New porch, rear extension and extend and alter roof to form a fourth bedroom, box room and shower.

44 Jubilee Avenue Rustington

*My Council has considered this application and wishes to object to it on the following grounds:-*

**To form
New Porch
Family Room
And 4th. Bedroom**

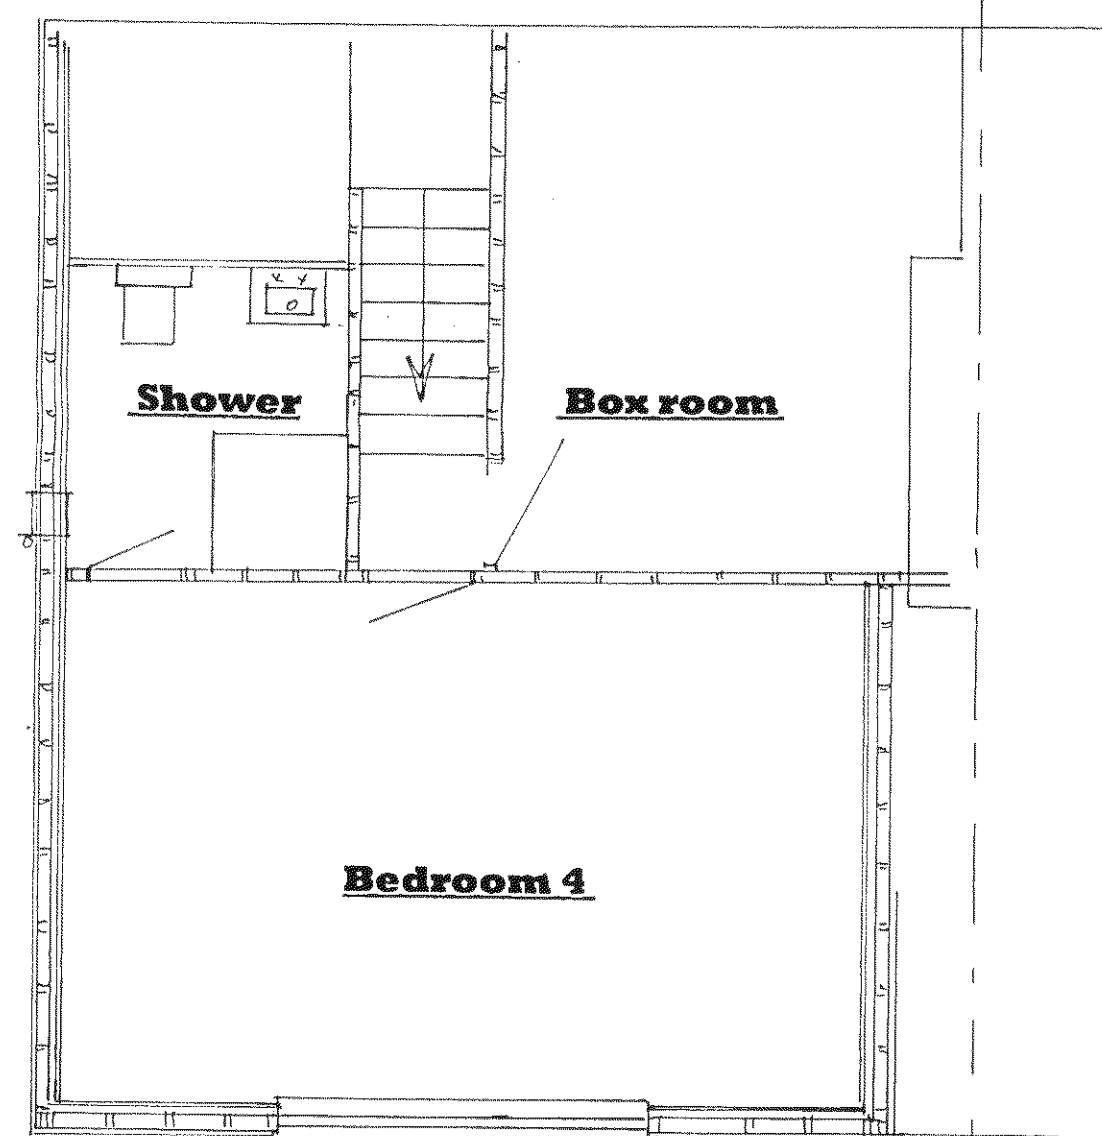
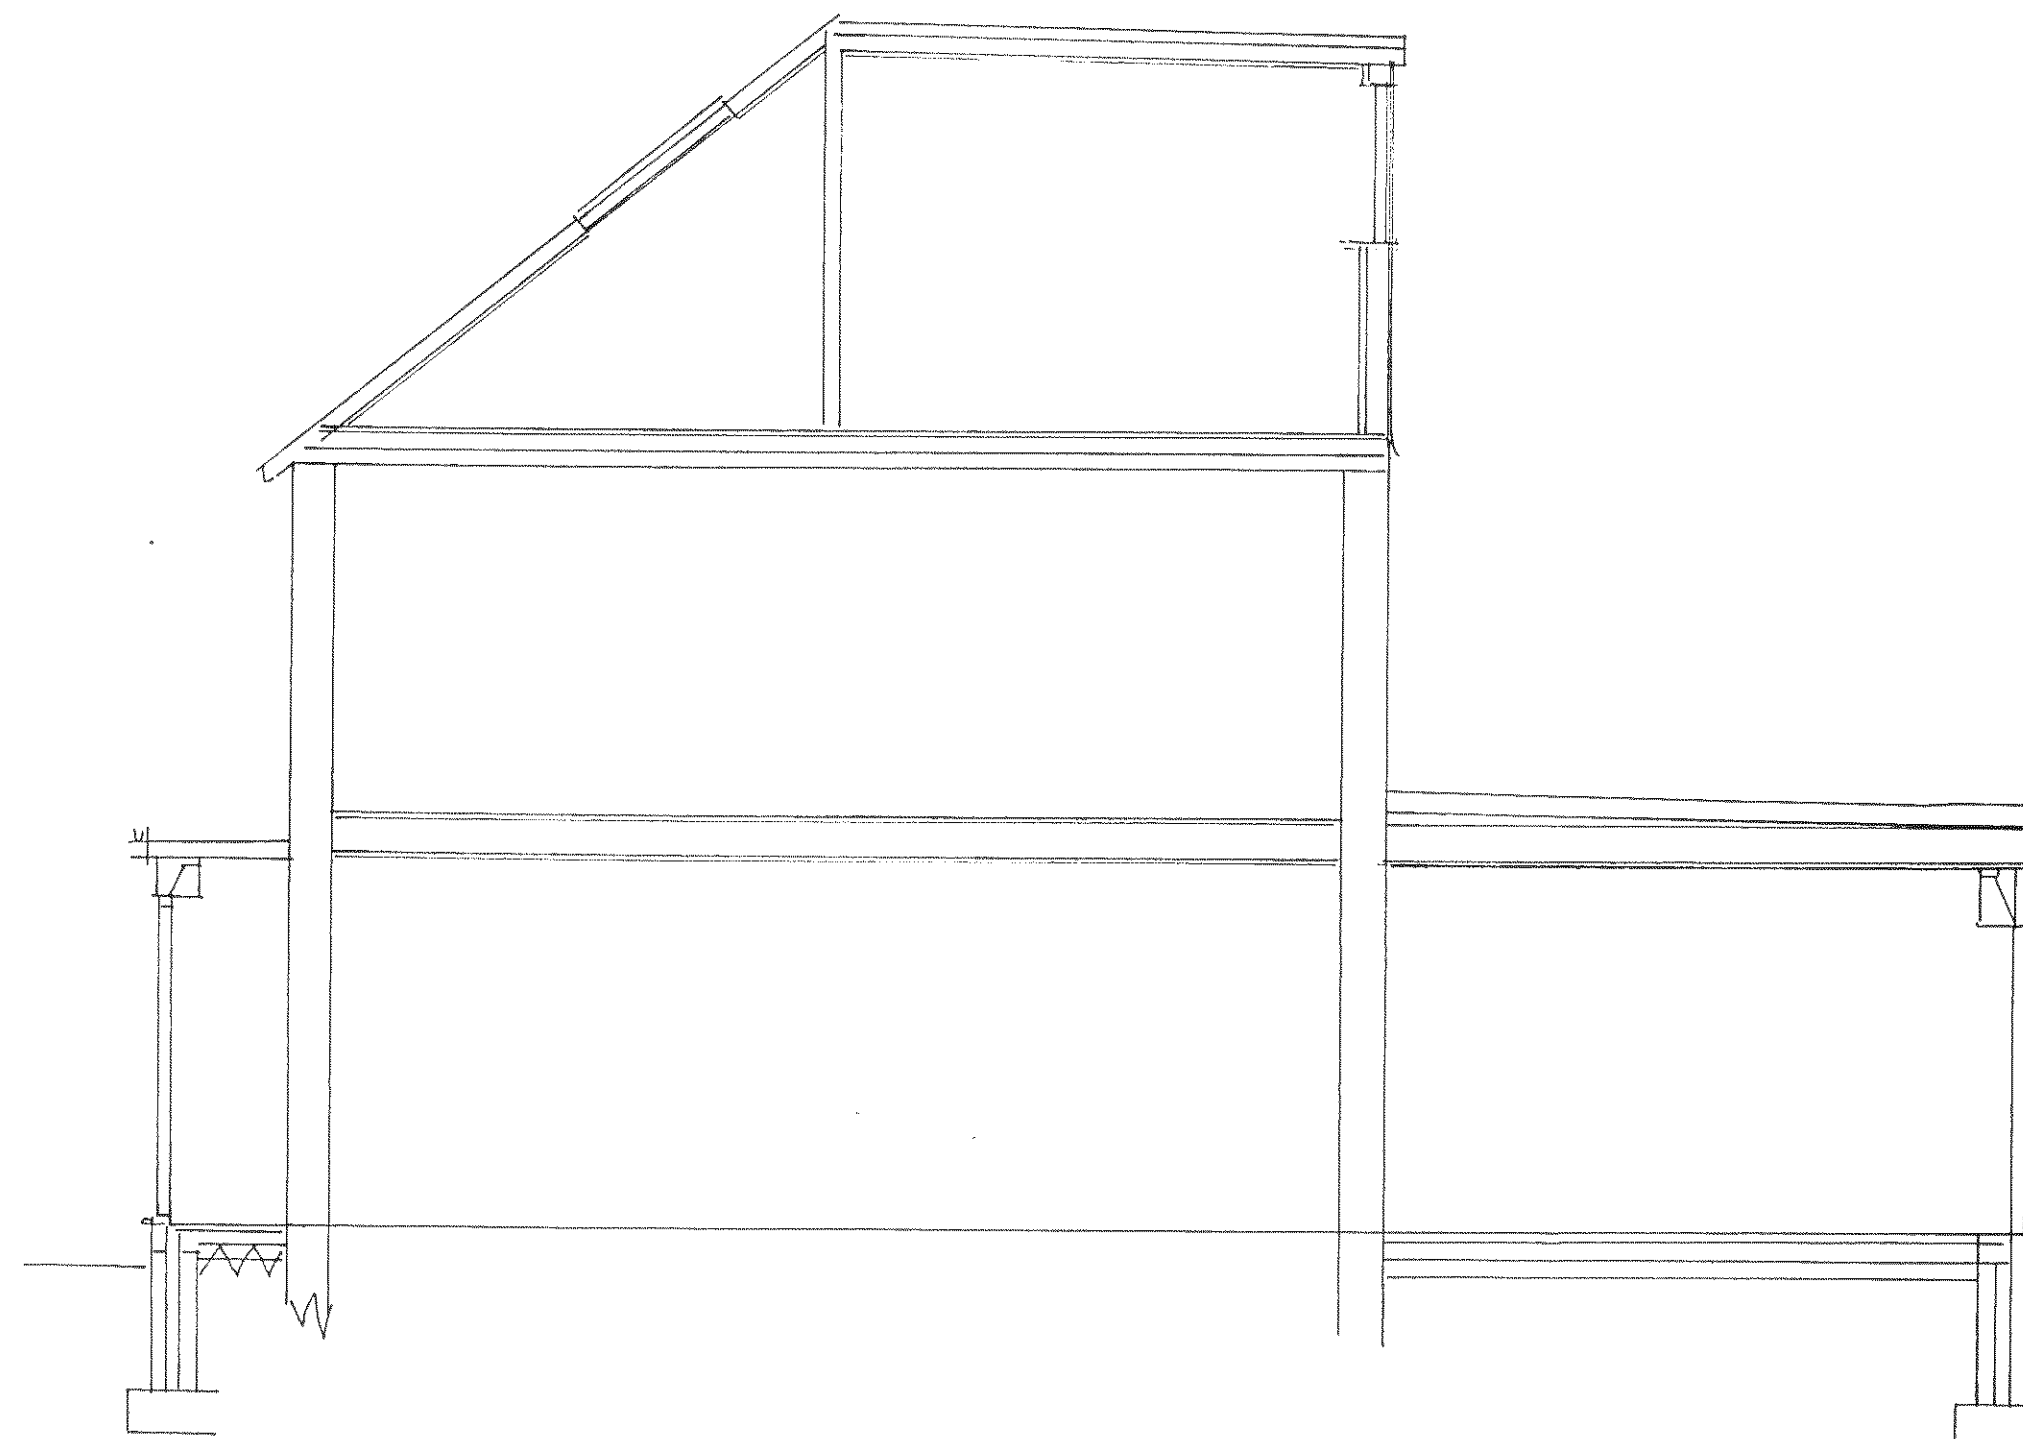
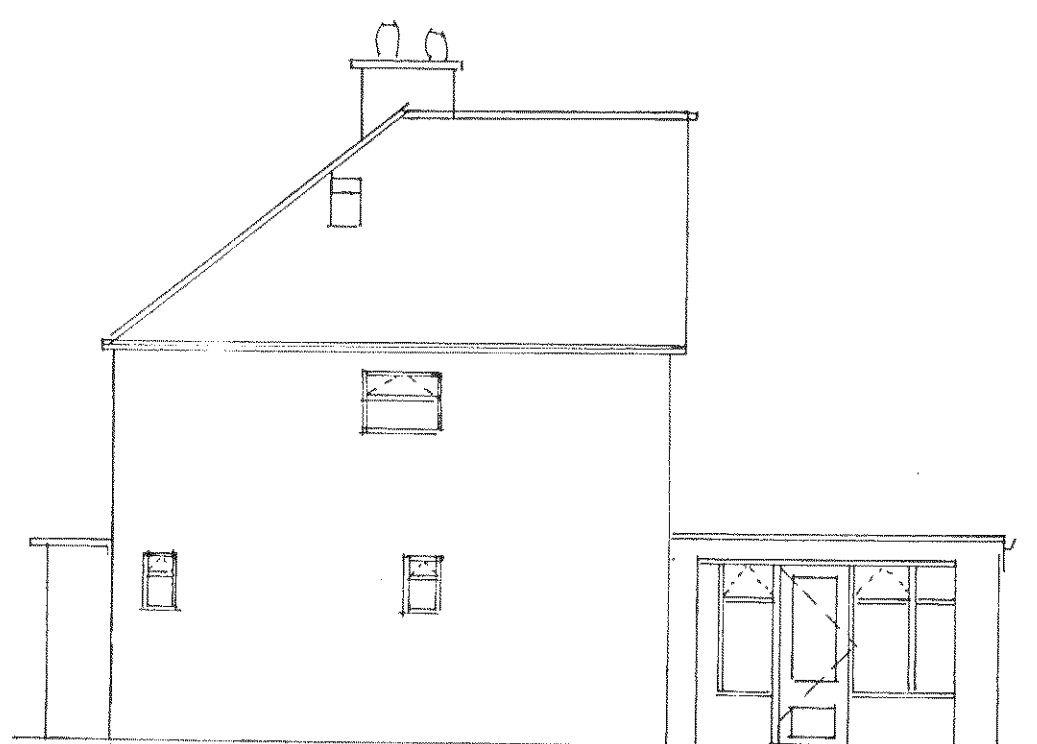
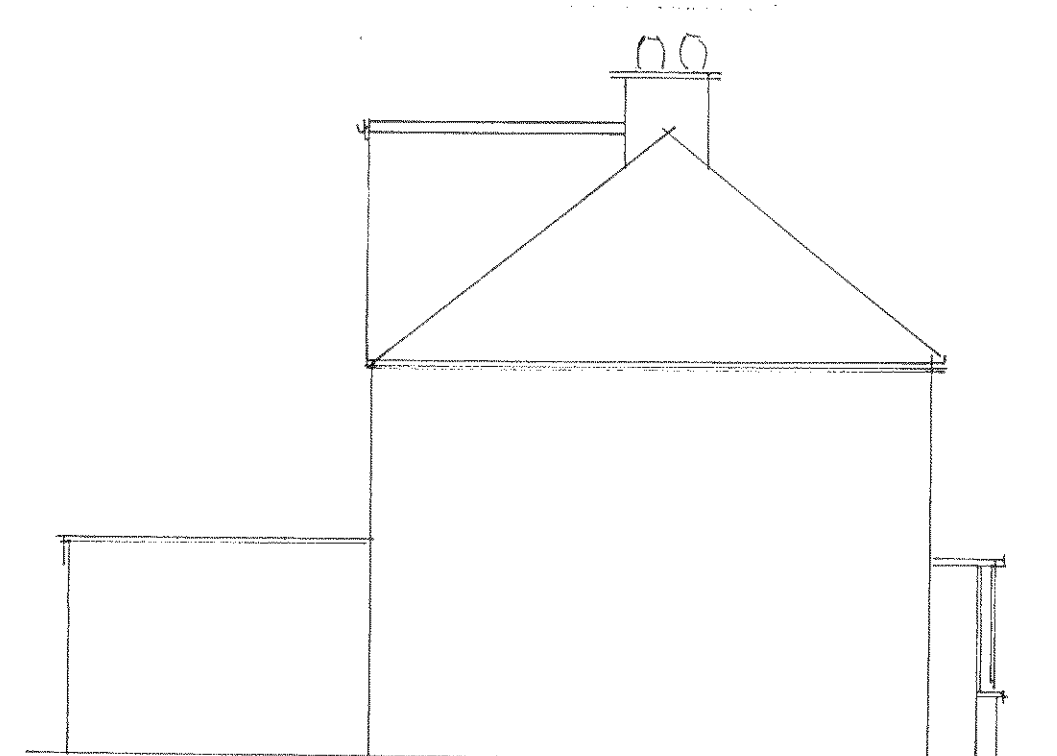
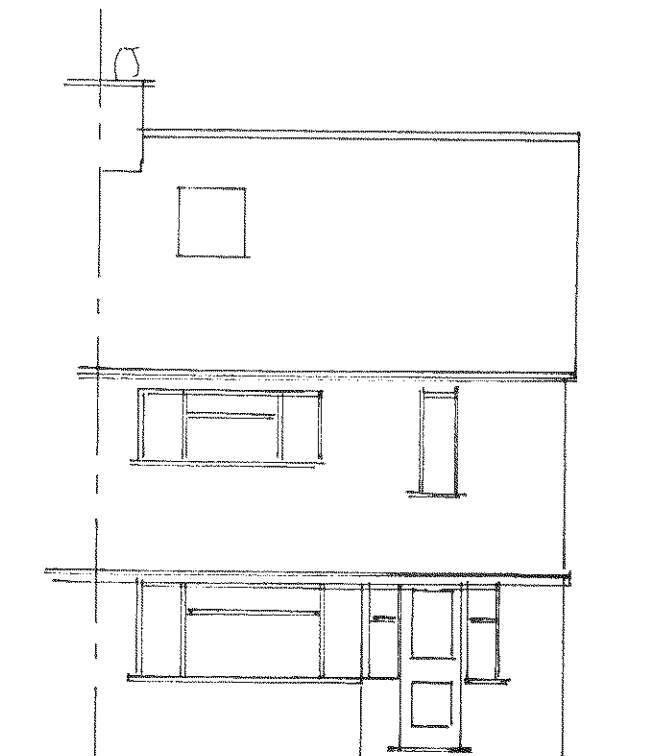
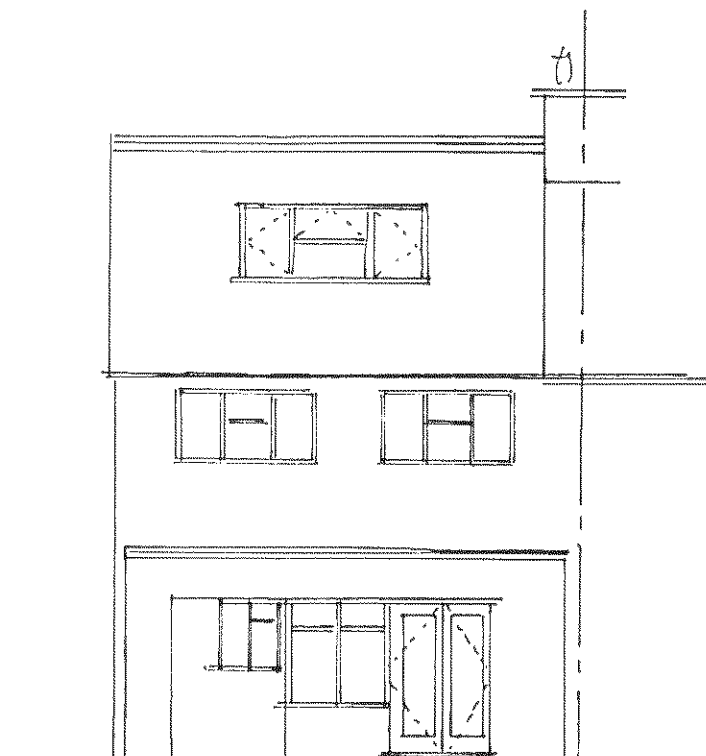
*(i) The proposal, by reason of its height and mass, would present an over-bearing appearance which would result in a loss of light and privacy for the occupiers of No. 42 Jubilee Avenue. It would, therefore, have a detrimental effect on the visual amenities and quiet enjoyment of the occupiers of the aforementioned property, together with other neighbouring properties within close proximity of the site, and in particular, No. 46 Jubilee Avenue.*
